Engineers Comments Regarding Surface Water Drainage

Application Reference:	Y/19/25/DOC	Reviewer Reference:	ADC/EXT4
Planning Officer:	Simon Davis	Date of Review:	14/11/2025
Site Name:	Land North of Yapton C of E Primary School North End Road Yapton		
Application Description:	Approval of details reserved by condition imposed under reference Y/88/18/OUT relating to condition number 17 - surface water drainage system.		
Assessment Number:	2 of 2

Application Reference: Y/19/25/DOC Site Name: Land North of Yapton C of E Primary School North End Road Yapton	Initial Issue Date: 14/11/2025 Issue Date: 14/11/2025 Reviewer Reference: ADC/EXT4
---	---

Section Pictures - 25/10/2024 - S65X

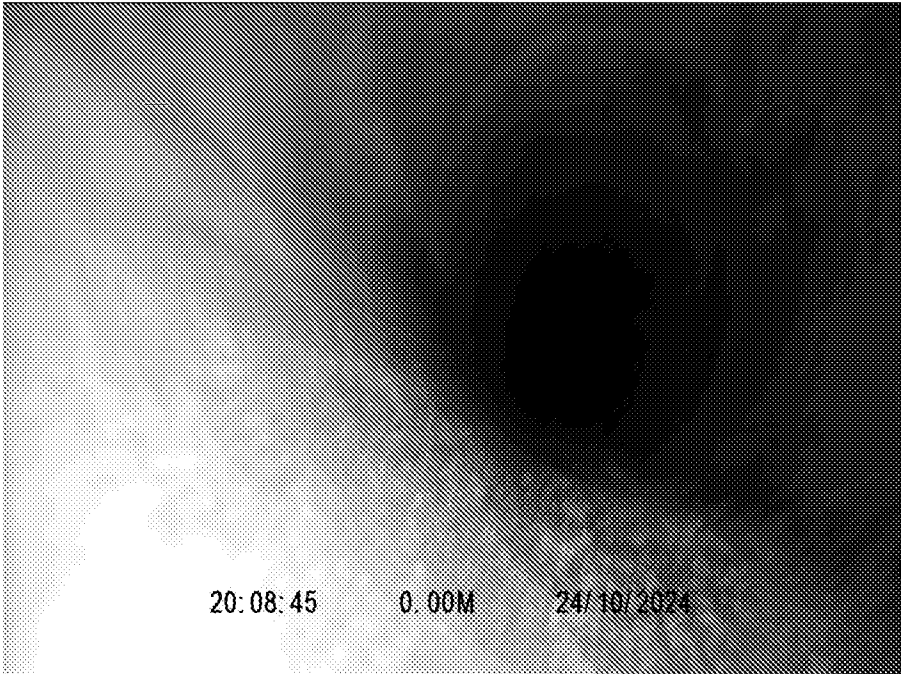
ADC Response (27/06/2024): Agreed and closed.				
4.	ADC Drainage Comments (20/03/2024): Provide CCTV survey video footage (including reports) of pipelines. Designer Response (02/05/2024): CCTV can be downloaded via the link: https://we.tl/t-1LIDPADROc ADC Response (27/06/2024): The video for S65-S66 is showing several sections of pipes to contain standing water due to potential blockage due to the presence of silt and debris. Also there are sign of a damaged pipe. The damages should be repaired and the pipe sections to be cleaned. ADC Drainage Comments (16/06/2024): Comment Closed				
5.	ADC Drainage Comments (20/03/2024): Provide the approved and the as-built finished levels.
